Aspen View Marksheffel 2

SC - Sign Application

SC1842

EL PASO COUNTY PLANNING & COMMUNITY DEVELOPMENT  
SIGN APPLICATION

CLIENT:
ASPEN VIEW HOMES
FILE NAME:
AVH LR 8 X 6 (SOUTH LINE OF FONTAINE EAST OF MARKSHEFFEL)
DESIGNER:
URBANOWICZ

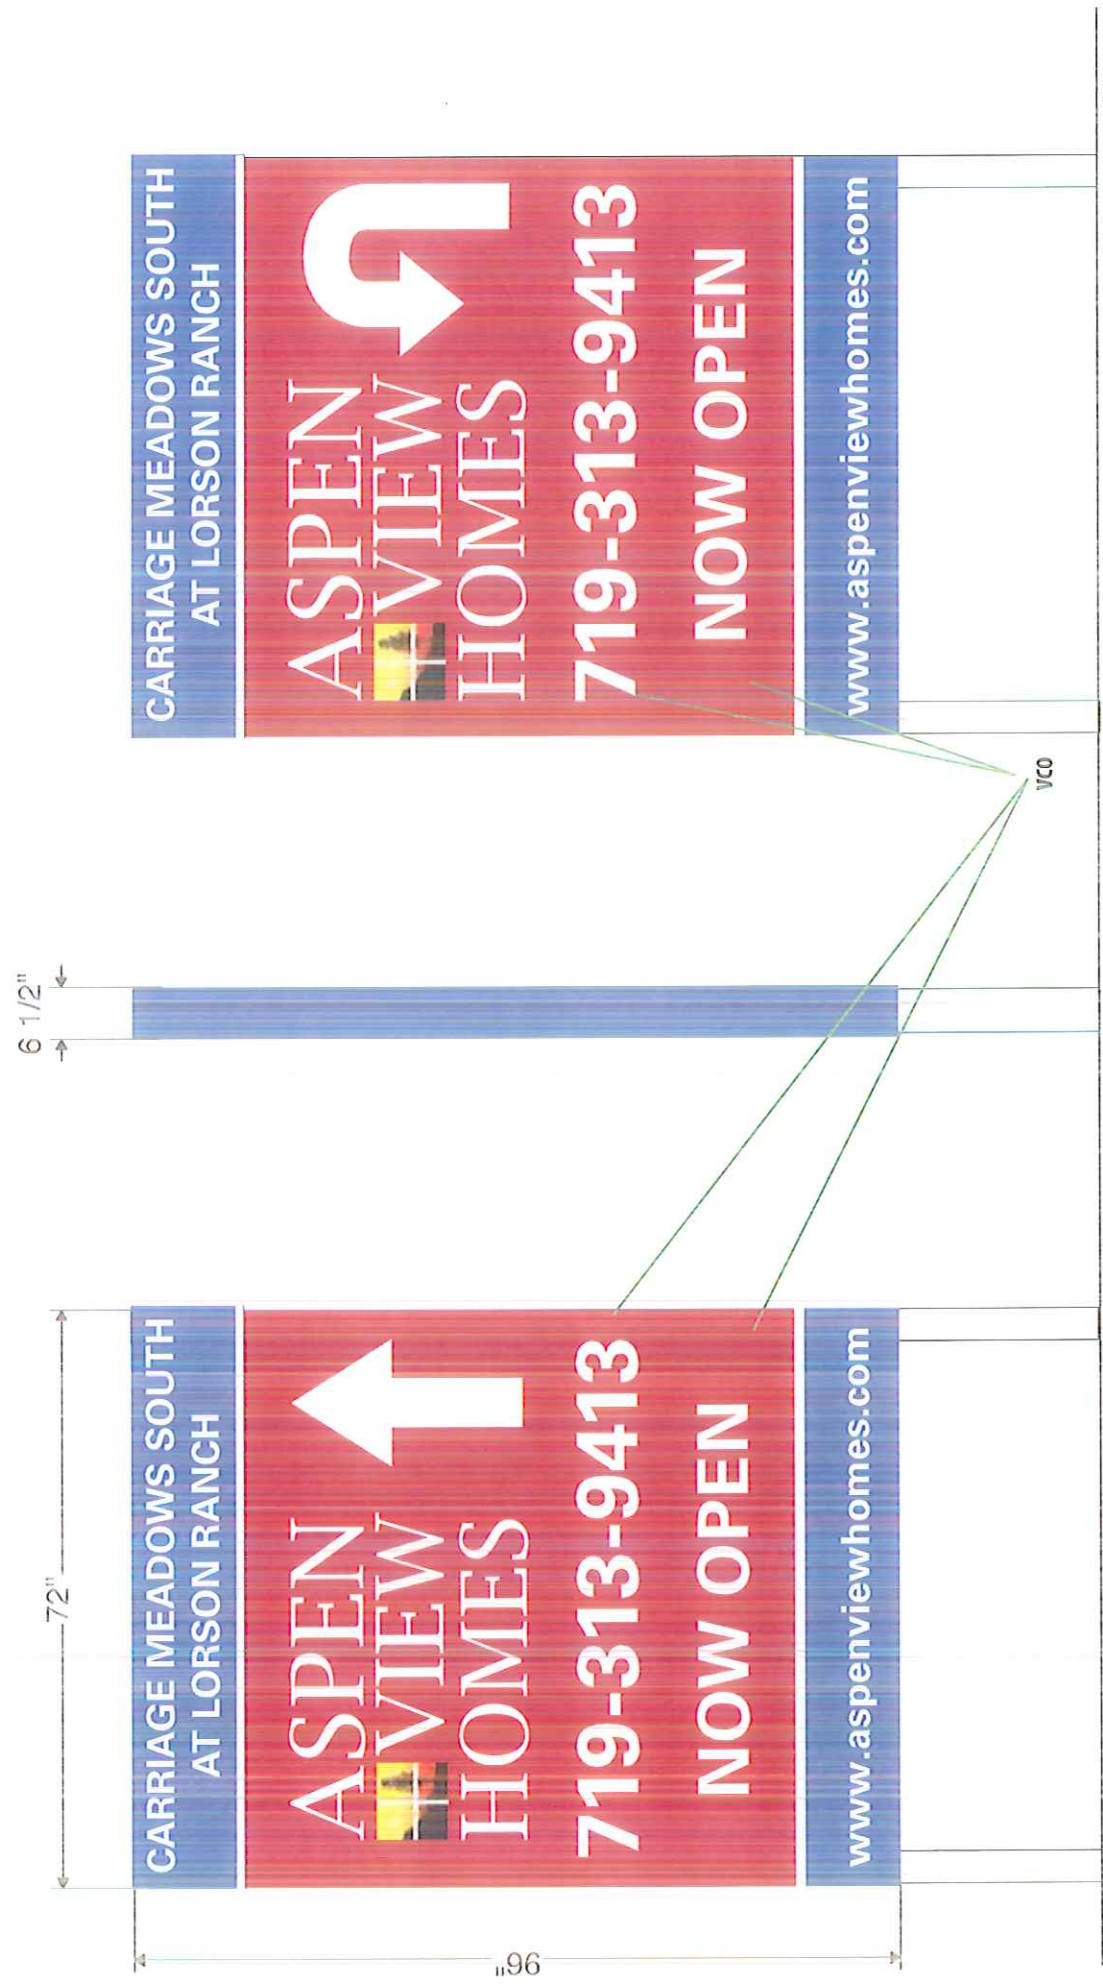
Do Not show this if it is not the sign you are applying for.
